RE: Corey Short Plat (SP-07-163)

The Kittitas County Community Development Services Department has determined that the Corey Short Plat (SP-07-163) is a complete application and hereby grants **conditional preliminary approval** subject to the following conditions:

MITIGATED DETERMINATION OF NONSIGNIFICANCE

- Project:** Corey Short Plat (SP-07-163)
- Description:** A 4-lot subdivision of approximately 22.43 acres of land zoned Agriculture-20.
- Proponent:** Robert Corey, Landowner
2963 Schnebly Road
Ellensburg, WA 98926
- Roger Weaver, Authorized Agent
700 E Mountain View, Suite 504
Ellensburg, WA 98926
- Location:** The project is located northeast of the City of Ellensburg, north of Brick Mill Road, east of Naneum Road, west of Fairview Road on Rader Road, Ellensburg, WA 98926, located in a portion of Section 15, T18N, R19E, WM, in Kittitas County. Map numbers 18-19-15000-0004 and 18-19-15000-0019.
- Lead Agency:** Kittitas County Community Development Services

COREY SHORT PLAT
 PART OF SECTIONS 15 & 16, T. 18 N., R. 19 E., W.M.
 KITITAS COUNTY, WASHINGTON

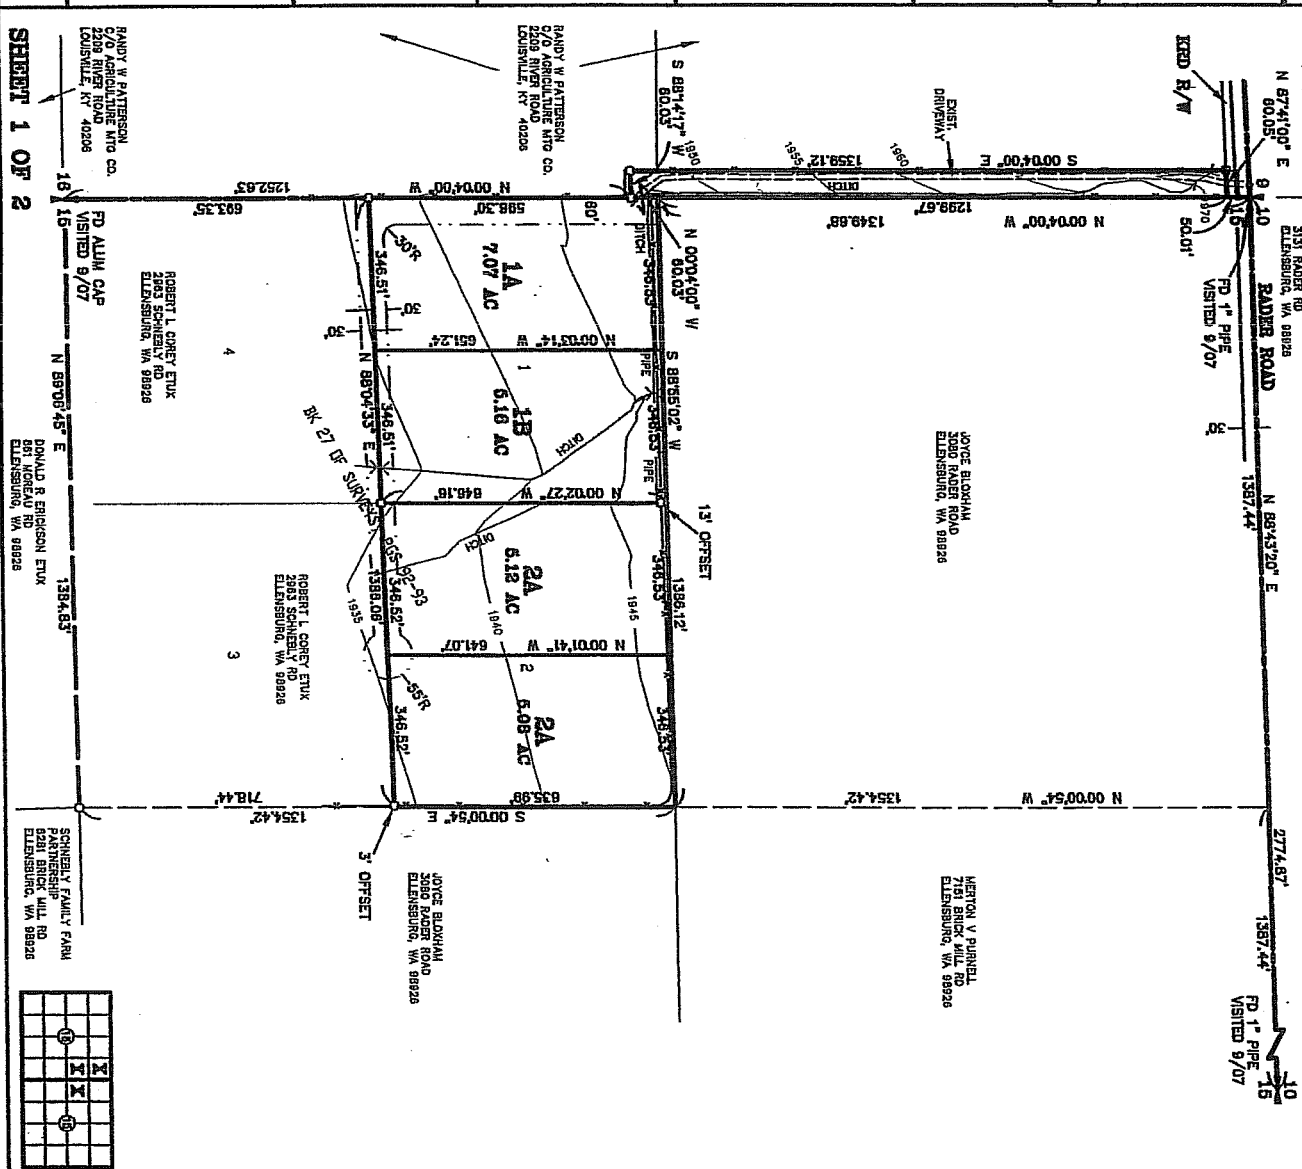
1. Both sheets of the final mylars shall reflect short plat number SP-07-163 and an accurate legal description shall be shown on the face of the final plat.

4. **The following plat notes shall be recorded on the final mylar drawings:**
 - All development must comply with International Fire Code.
 - This short plat has exhausted the use of the one-time split provision allowed per Kittitas County Code. No further one time splits are allowed for the subject parcels and subsequent parcels created via this short plat.

- The subject property is within or near existing agricultural or other natural resource areas on which a variety of activities may occur that are not compatible with residential development for certain periods of varying duration. Agricultural or other natural resource activities performance in accordance with county, state and federal laws are not subject to legal action as public nuisances. Kittitas County has adopted the right to farm provisions contained in Section 17.74 of the Kittitas County Zoning Code.

- The subject property is to be served by a "Group B" water system designed by a licensed engineer and approved by Kittitas County Environmental Health. The "Group B" system is to serve the four lots created by the Corey Short Plat (SP-07-163) and the four lots created by the Guest Short Plat (SP-07-162) COMBINED, serving a total of 8 (eight) lots.

- The "Group B" water system shall have flow meters installed at both the well head and on each individual lot. Records documenting water usage for each meter must be maintained and must be readily available for public inspection by a Satellite Management Agency (SMA).
